2023/0643

Erection of decorative gateway and railings

Thurnscoe Community Plaza, Houghton Road, Thurnscoe, Rotherham, S63 0JS

ELEVATION FROM OUTSIDE

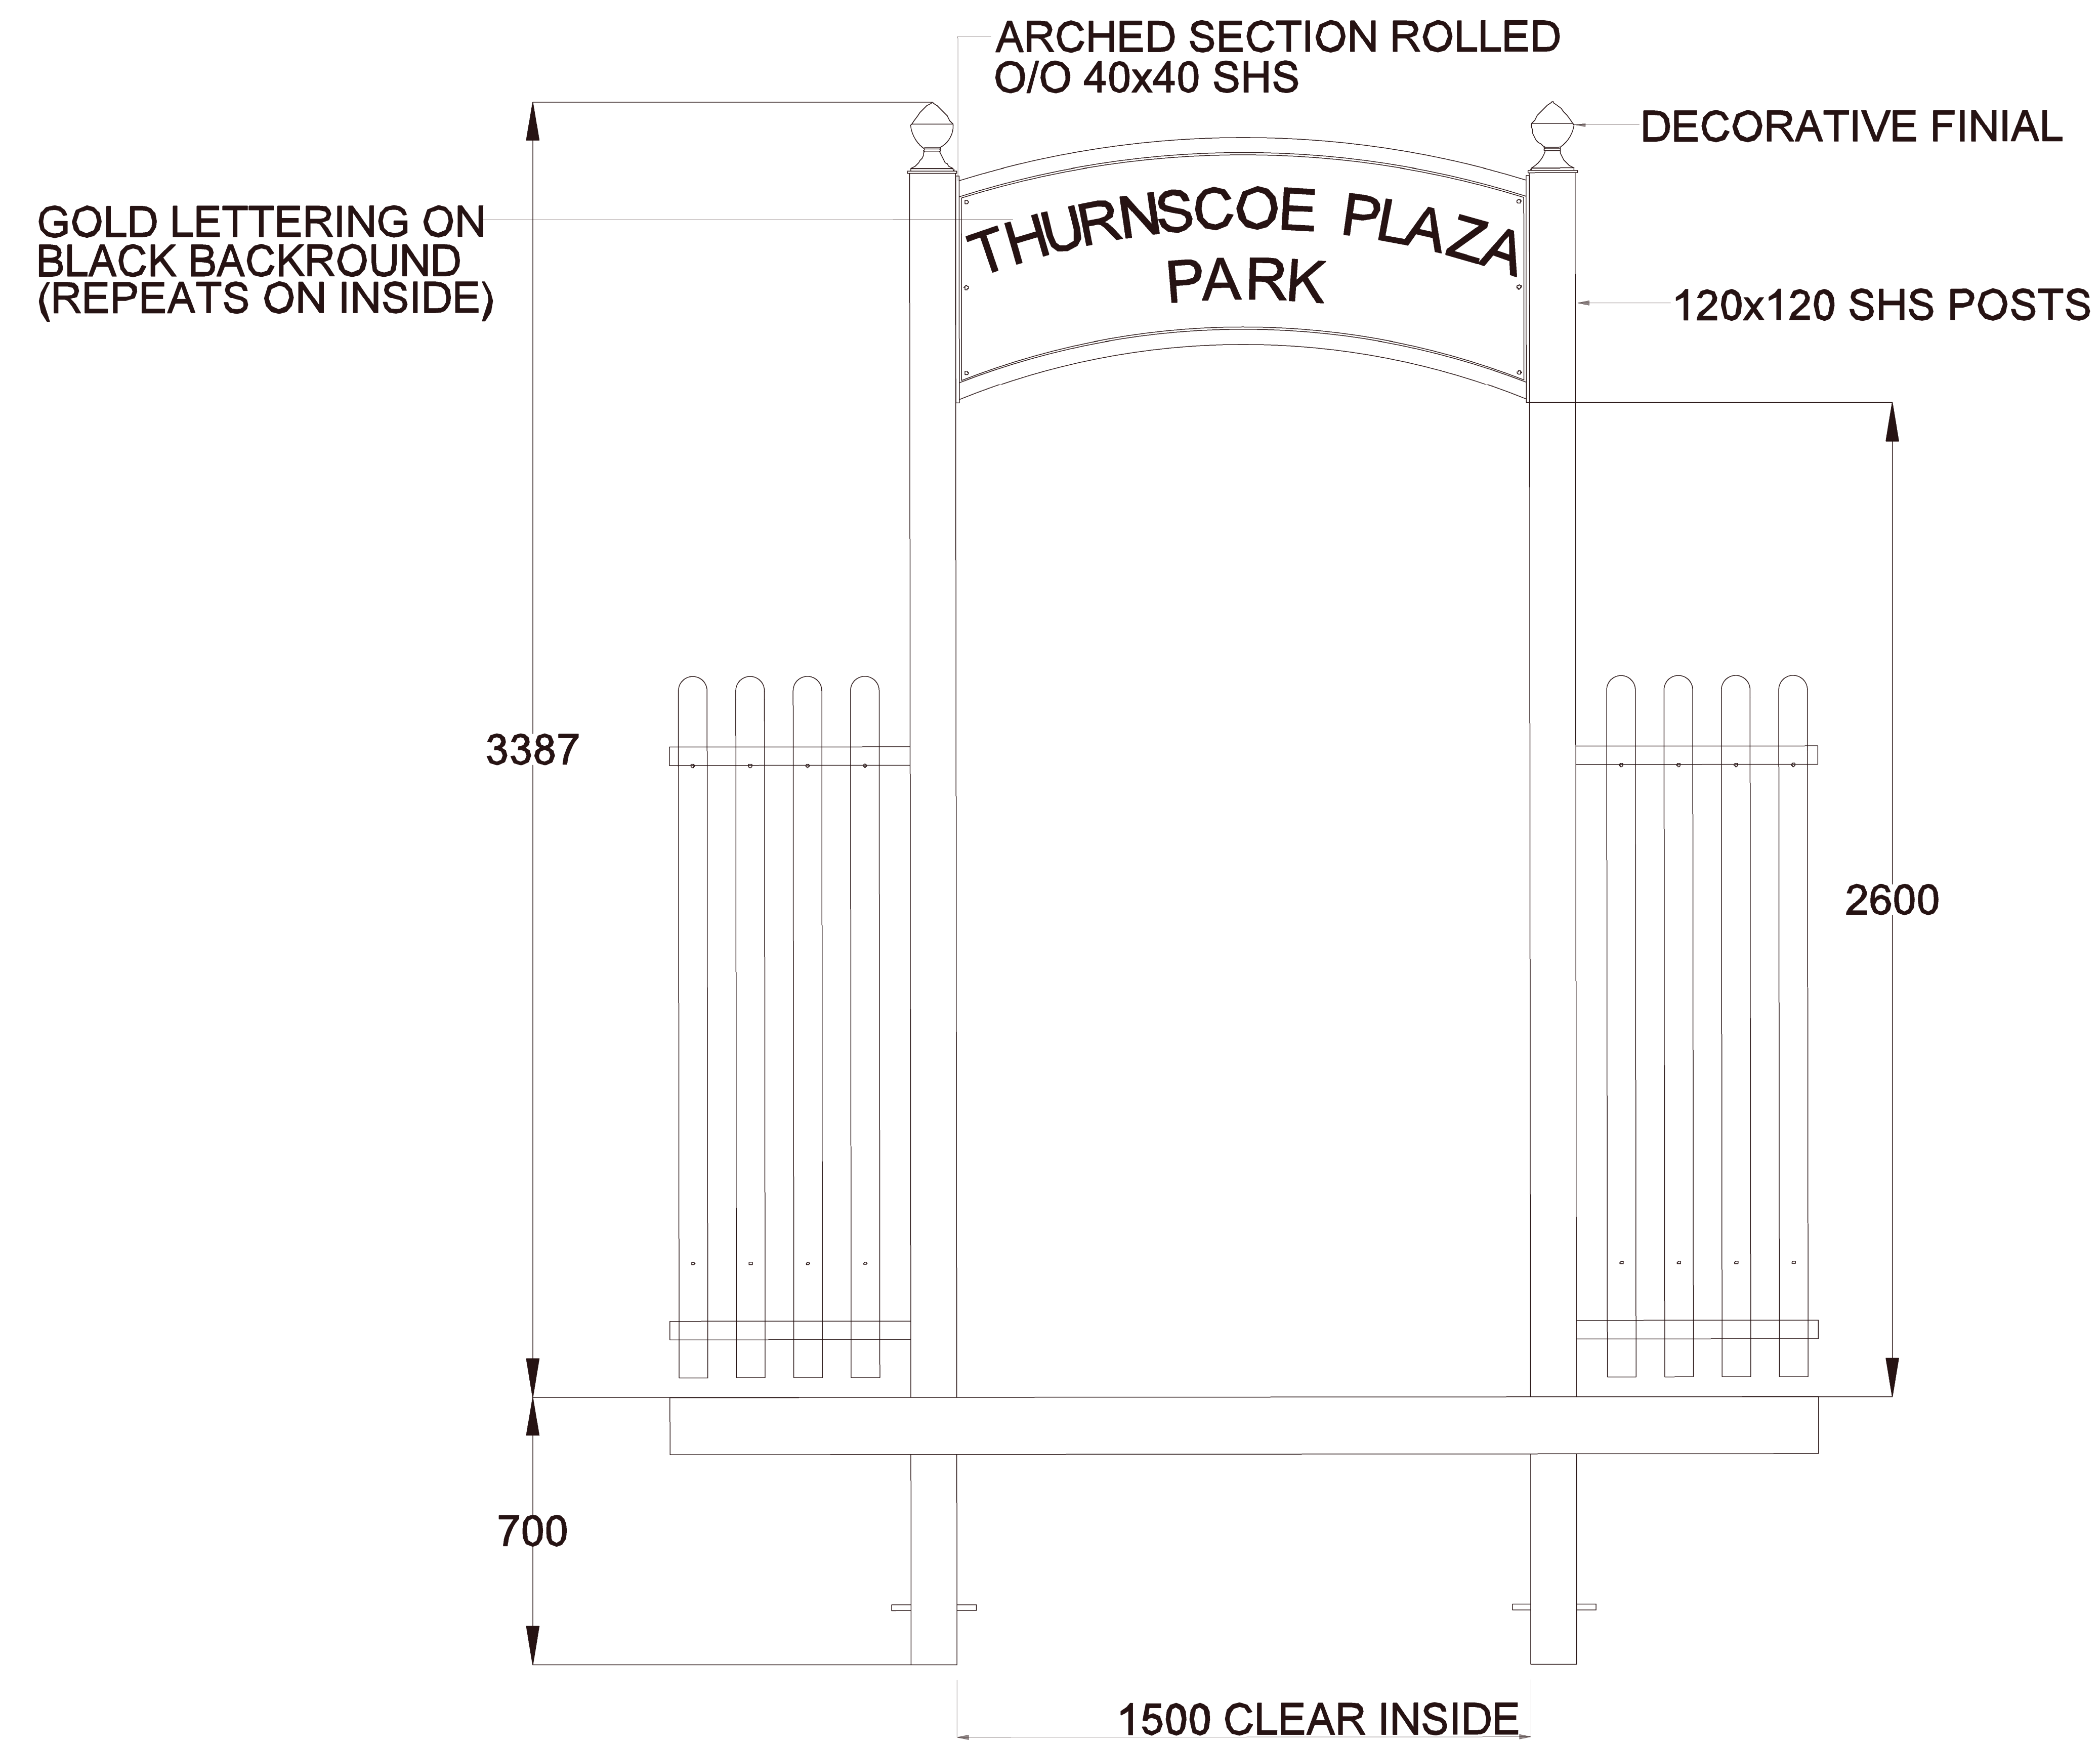
The proposal involves the erection of decorative gateway and railings at the entrance to Thurnscoe Community Plaza. The plans have been amended during the course of the application at the request of the highways officer, the minimum height of the gateway was previously shown at 2.1m however, the minimum acceptable headroom over cycleways, footways and footpaths is 2.6m . The applicant has now increased the height of the gateway to 2.6m. The existing palisade fence will remain.

The plans have been subject to discussions with the Highways Section. Whilst the gateway is set back from the public highway, the minimum headroom over cycleways, footways and footpaths is 2.6m. The gateway has now been amended to 2.6m minimum height as requested by the Highways Officer, which is now acceptable in terms of Highway Safety and the proposal would not impede visibility to the footpath or Houghton Road, in accordance with policy T4 of the Local Plan.
